The following are the comments and objections to both the planning applications relating to Oakenshaw Cross. These are sent on behalf of Residents of Oakenshaw .

Return of the cross

Drawing Title General Arrangement and Detail Drawing

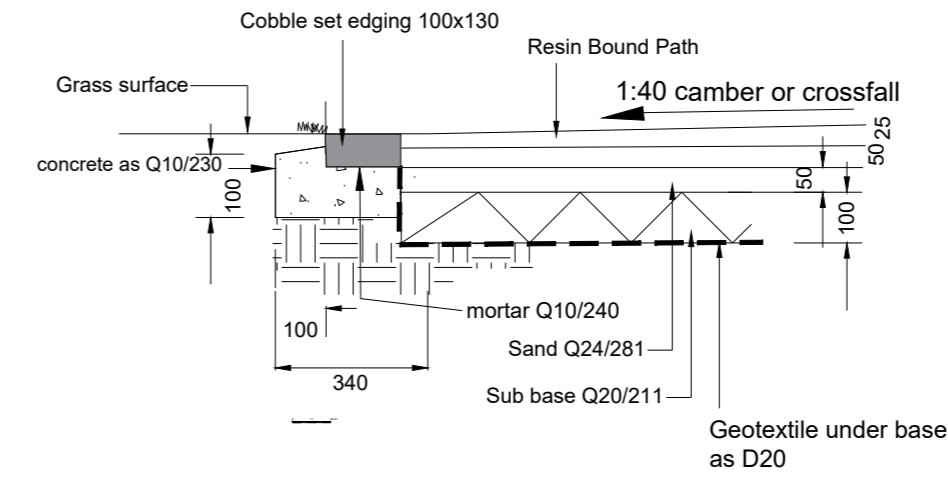
The Cross is important to Oakenshaw , it is reported to be the only surviving monument of its type in Kirklees. It was commissioned by Dr Richard Richards of Bierley Hall as a memorial to his late wife. It has stood on Wyke Lane for over 300 years and being on the road means it can be seen , to move it down to the left on the grass will mean it cannot be seen from the main road as now.

This sadly reflects the lack of consultation with the residents and the monument group who have been meeting with the council to discuss this over the years during which our cross has languished in an insecure yard . There has been no explanation of why it can't be returned to its original position or whether the proposed site's foundations can take the weight of the monument .
